Maughanaclea Wind Farm Observation

Case reference: PAX04.324165

Description: 10-year planning permission for Maughanaclea Wind Farm consisting of 14 no. wind turbines, a 110kV substation and 110kV underground cabling connection and associated works by Maughanaclea Ltd

Applicant: Maughanaclea Ltd, Enerco

Figure C: Site Drainage Map

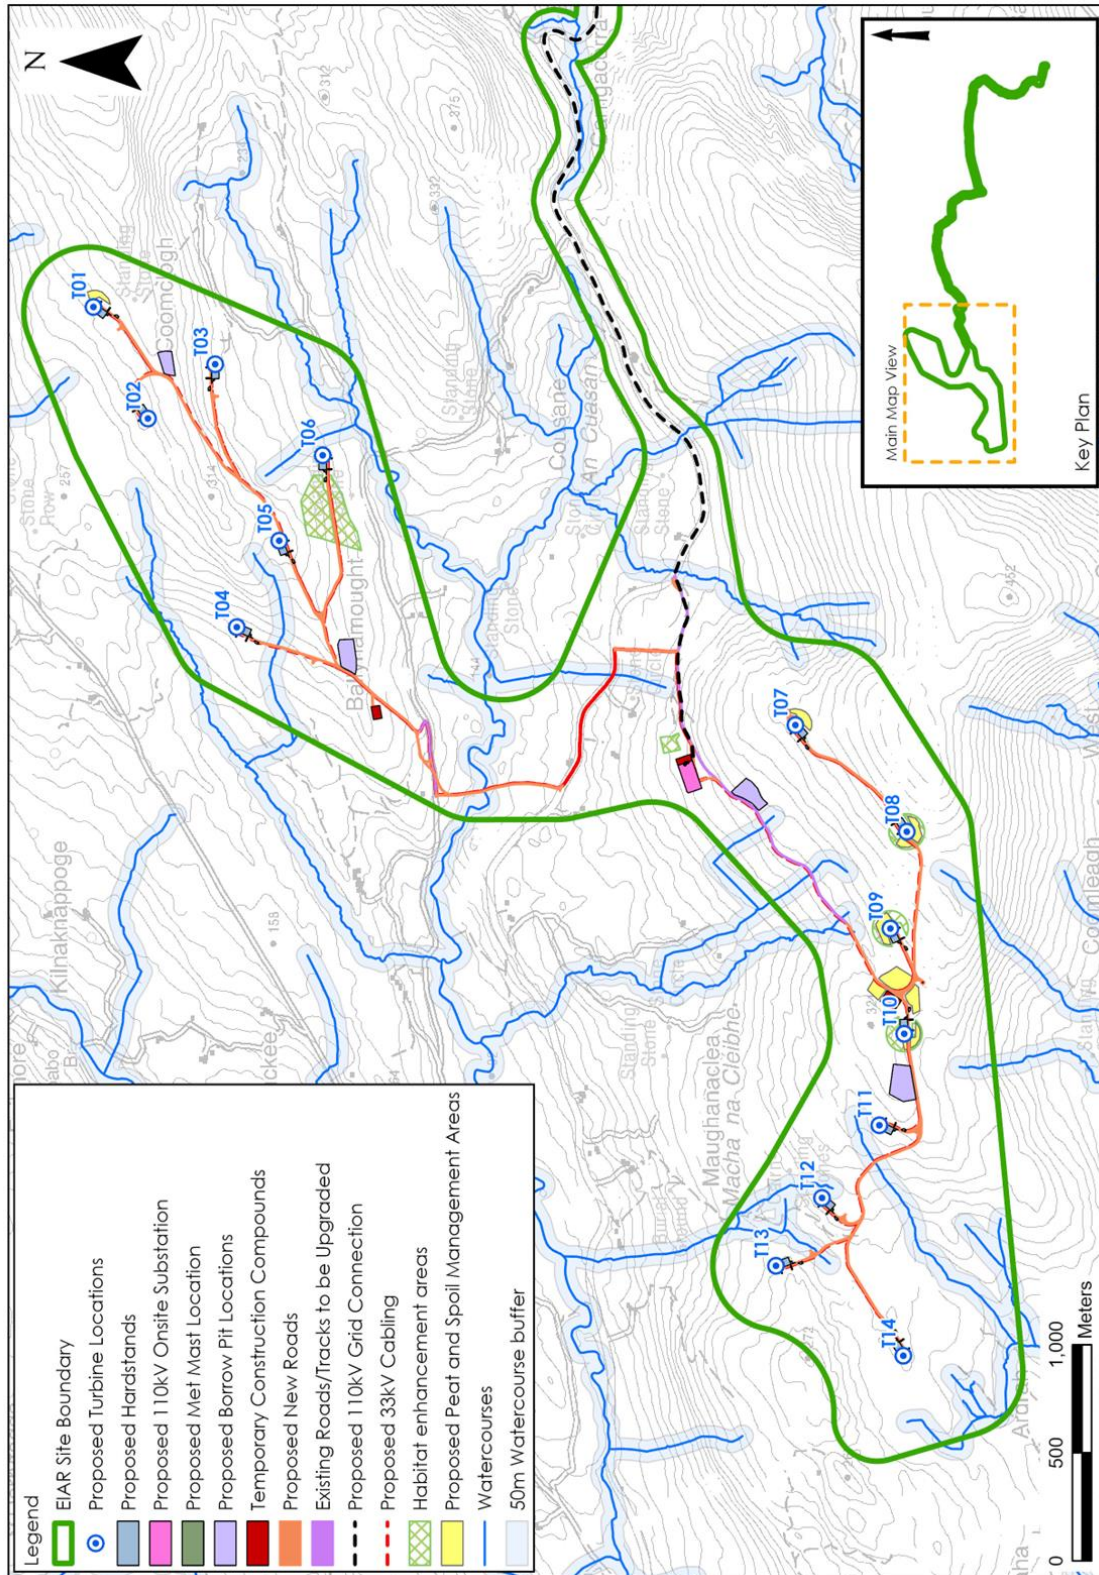
Chapter 9 of the Environmental Impact Assessment Report (EIA) and the accompanying Flood Risk Assessment (Appendix 9-1) are founded on an incorrect identification and mapping of a watercourse, which constitutes a material defect in the hydrological baseline and undermines the reliability of the flood risk assessment and proposed mitigation measures.

Page 15 of Appendix 9-1 (Flood Risk Assessment) incorrectly describes a watercourse as a tributary of the Maughanaclea River. This description is factually incorrect. Based on the on-the-ground hydrology, the watercourse:

The focused mapping extract within the EIAR further highlights this discrepancy. The watercourse alignment shown in Appendix 9-1 does not correspond with the watercourse as it exists on the ground.

This misidentification of the receiving watercourse results in an incorrect catchment delineation, which directly affects the hydrological assumptions underpinning the Flood Risk Assessment (Appendix 9-1).

- Flow-path analysis and runoff modelling are unreliable;
- Flood extent predictions based on those assumptions are unsound;
- Flood mitigation measures designed on this basis may be inadequately sized or incorrectly located; and
- Residential properties identified as being outside areas of flood risk may, in fact, be subject to unassessed flood risk.
- Houses identified by the green dot may face increased and unassessed flood risk.

Figure A: Local Hydrology Map

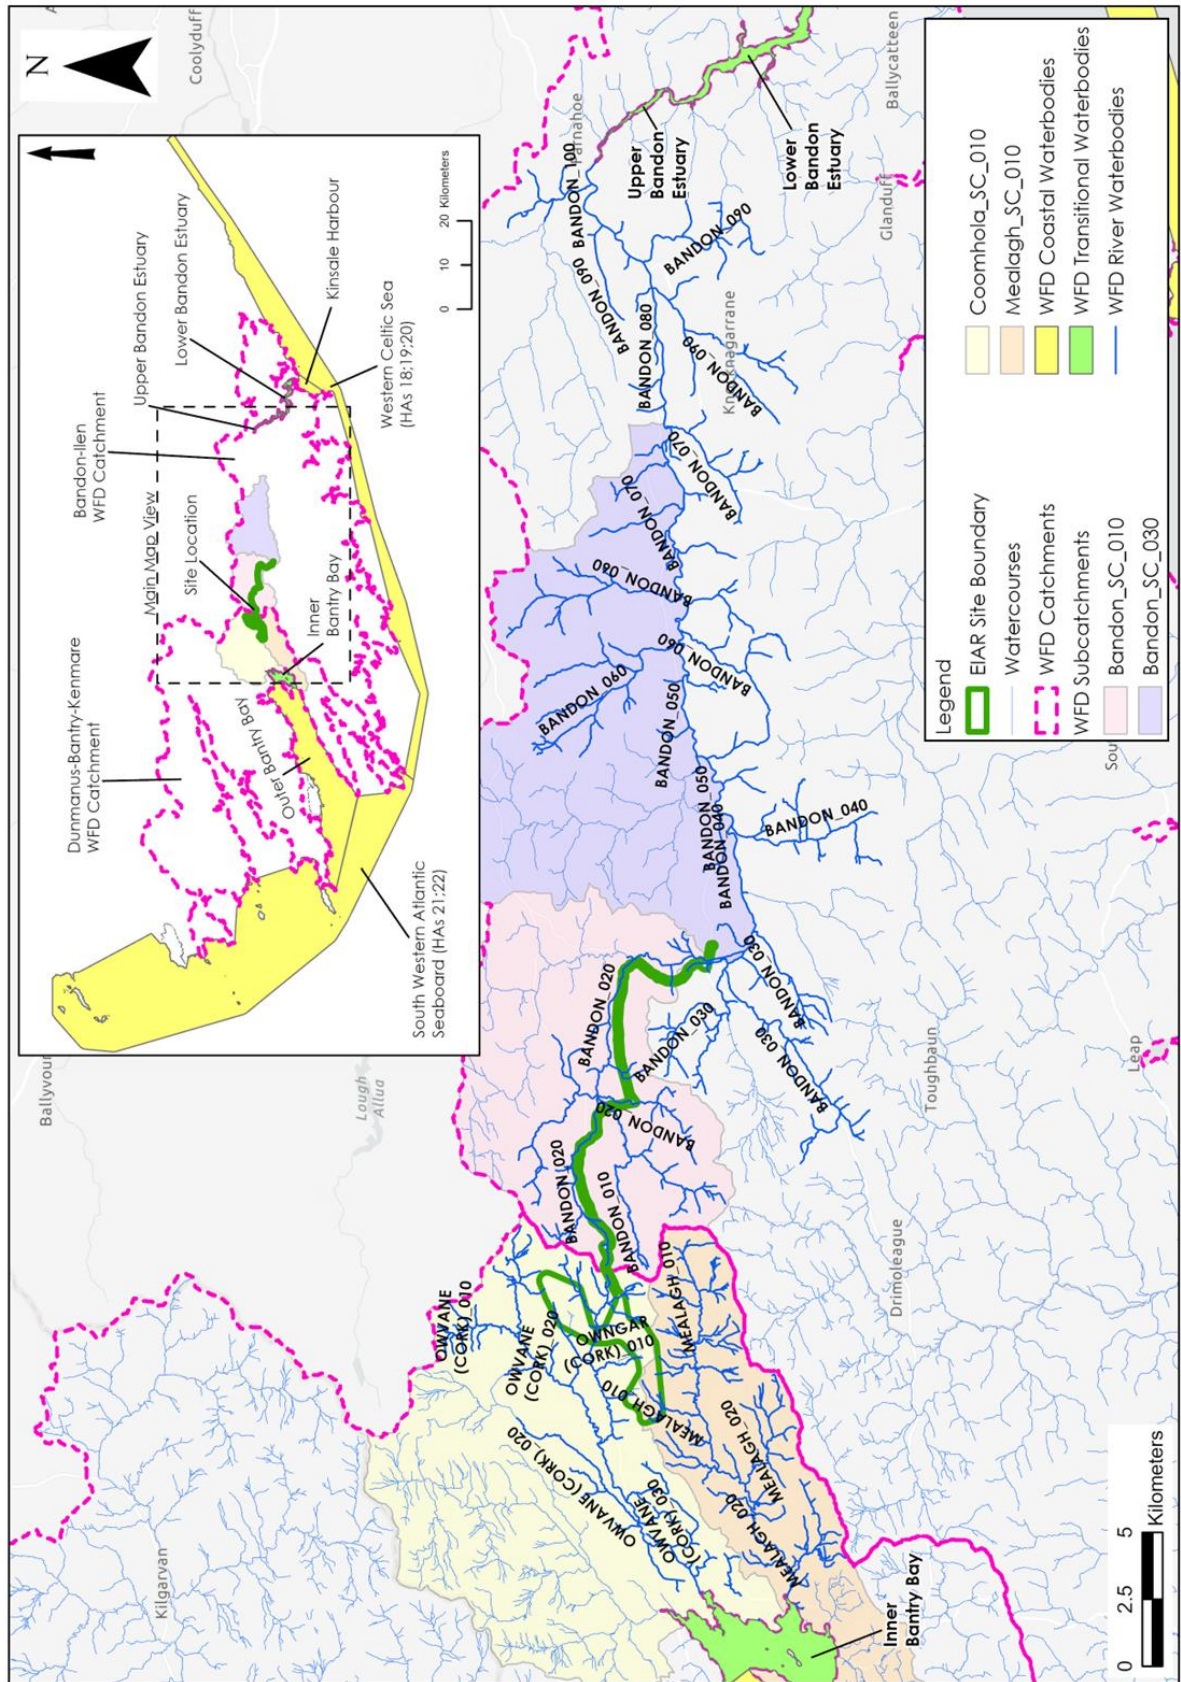
It does not discharge to the Maughanaclea River, notwithstanding repeated references to this effect within Appendix 9-1 and Chapter 9 (Hydrology and Hydrogeology) of the EIA, where the catchment

context and drainage pathways are described (refer in particular to Chapter 9, Sections 9.3.3, 9.3.5 and Figures 9-2 and 9-4).
